45-53 Macleay Street Potts Point

Response to Submissions

This Submissions Report has been prepared by Urbis on behalf of Time & Place Pty Ltd (**the Applicant**) to address the matters raised during the public exhibition of the State Significant Development Application (**SSDA**) for the redevelopment of 45-53 Macleay Street, Potts Point (SSD-79316759).

1 ENVELOPE - ELEVATION_SOUTH
1 : 200

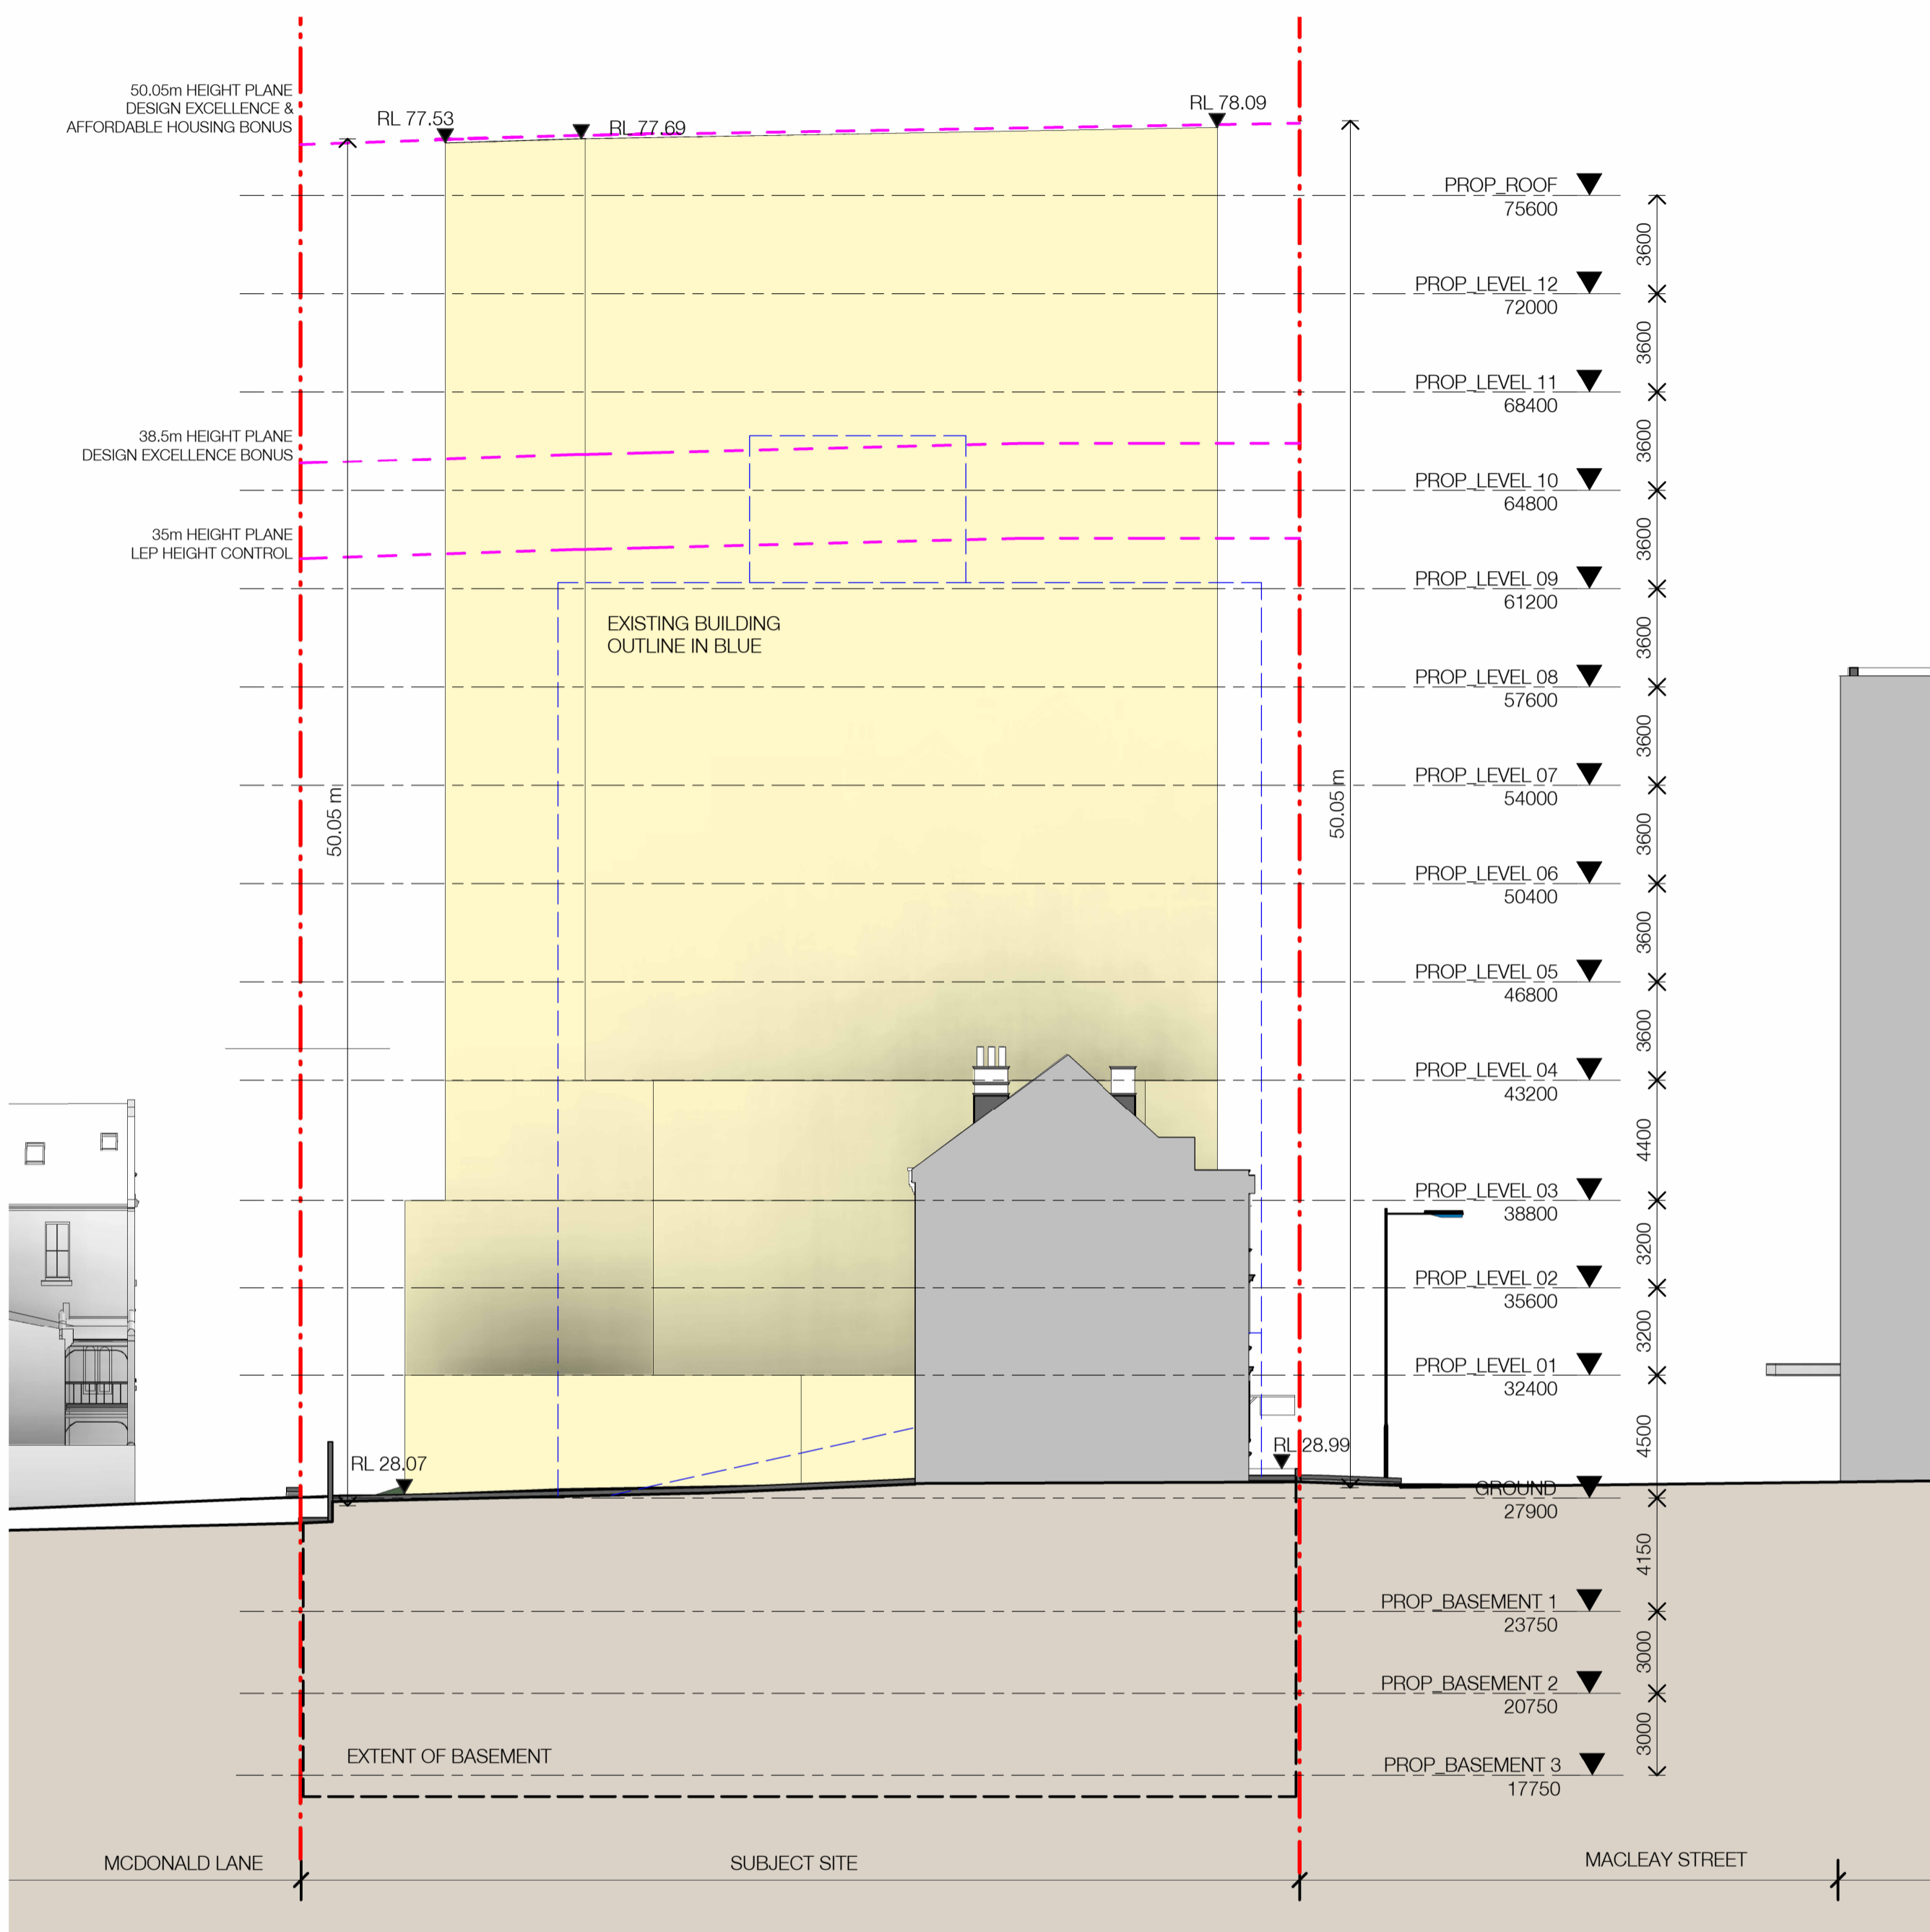
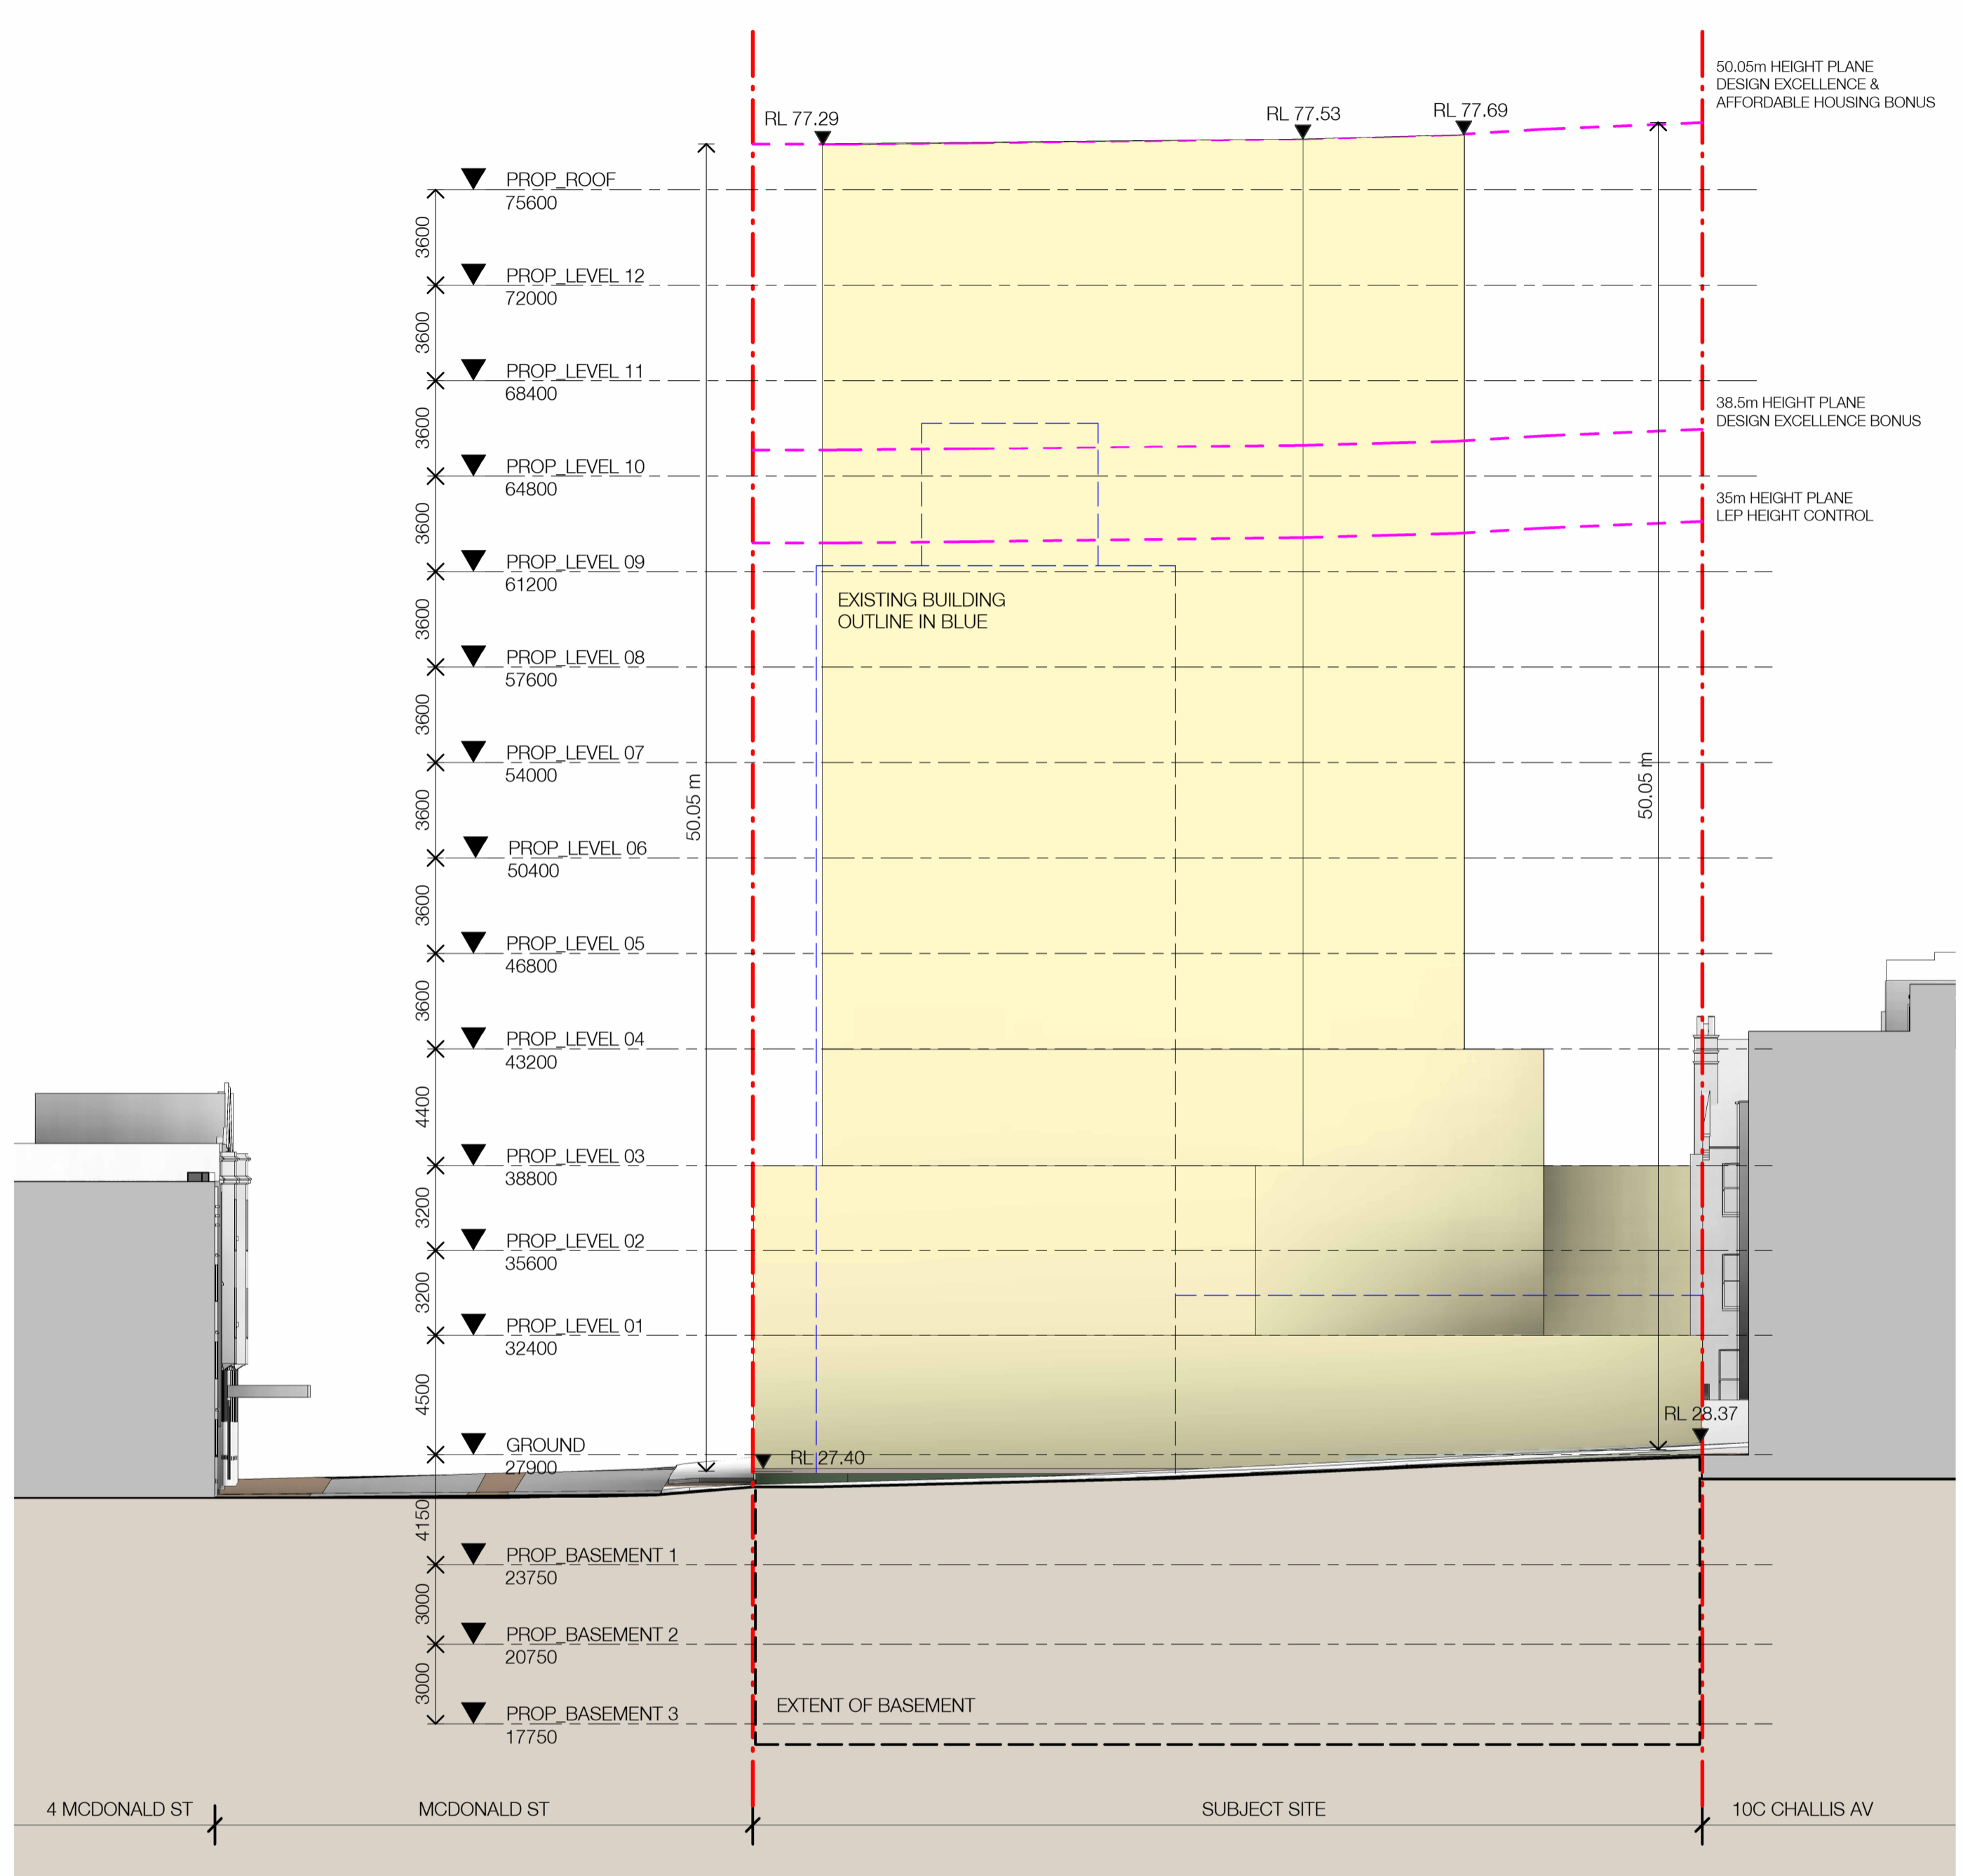
Issue Raised	Response	RTS Reference
Department of Planning, Housing and Infrastructure		
Building height		
<ul style="list-style-type: none"> ▪ Confirm that the building envelope height fully complies with the maximum building height permitted under State Significant Planning Policy (Housing) 2021 (Housing SEPP) by providing: <ul style="list-style-type: none"> – an overlay of the building envelope plan over the survey plan, with existing ground levels, contours and the uppermost points of the building envelope clearly notated – updated elevation plans dimensioning the uppermost points of the building envelope with the existing ground level directly underneath – an updated building height plane diagram which depicts the maximum height RIs for the site, and the maximum building envelope RIs, as the northern elevation appears to depict a building height breach. 	<p>Additional plans have been provided by SJB to confirm that the proposal fully complies with the maximum building height permitted under the Housing SEPP.</p>	<p>Appendix C</p>

1 ENVELOPE - SHADOWS - 9am
1 : 800

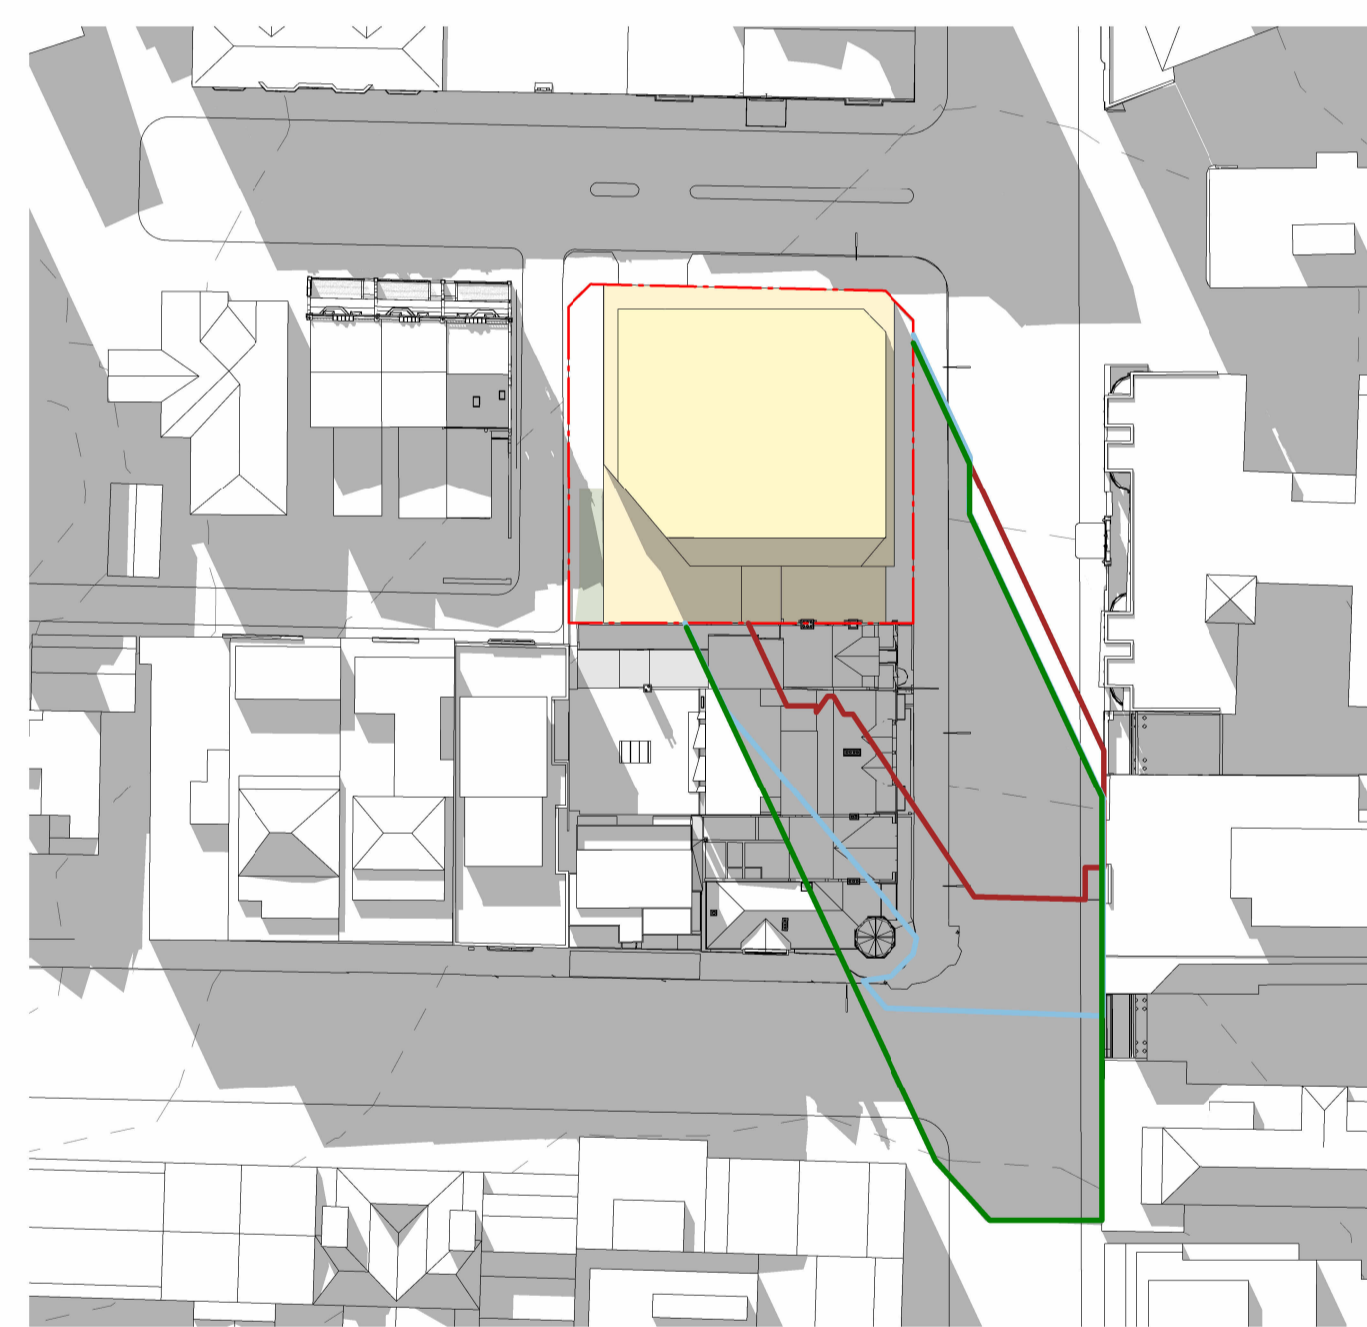
Overshadowing and solar access		
<ul style="list-style-type: none"> ▪ Public submissions raised concerns regarding overshadowing impacts to neighbouring residential properties. To enable a full assessment of these impacts, provide: <ul style="list-style-type: none"> – a detailed written analysis, to supplement the solar access analysis in the Design Report, which confirms which neighbouring residences will retain two hours solar access to their private open space areas and north facing living areas on June 21, including calculations of the amount of sunlight lost and retained – the written analysis is to address any specific overshadowing concerns raised in submissions – the solar access tables are provided at 15-minute intervals, however, the supporting solar access/ views from the sun are provided at hourly intervals. Provide additional diagrams that support the solar access tables. 	<p>SJB have provided a detailed analysis at Appendix E. In response to DPHI's request, the detailed analysis supplements the solar access analysis in the Design Report. Additional view from the sun diagrams have been provided by SJB at 15-minute intervals to support the solar access tables (Appendix E).</p> <p>The analysis provides a detailed summary of the neighbouring residences that will retain two hours of solar access to their living & private open spaces, and concludes the following:</p> <ul style="list-style-type: none"> ▪ 14 Macleay Street <ul style="list-style-type: none"> – There are 7 units (out of 35) that currently have more than 2 hours of sunlight to Living & POS – 1 unit (Unit 604) that currently has more than 2 hours of sunlight will lose access to 2 hours of sunlight to Living & POS as a result of the proposal – Unit 604, 14 Macleay Street will receive 1.75 hours and 3 hours sunlight access to living areas and private open space, respectively. 	Appendix E
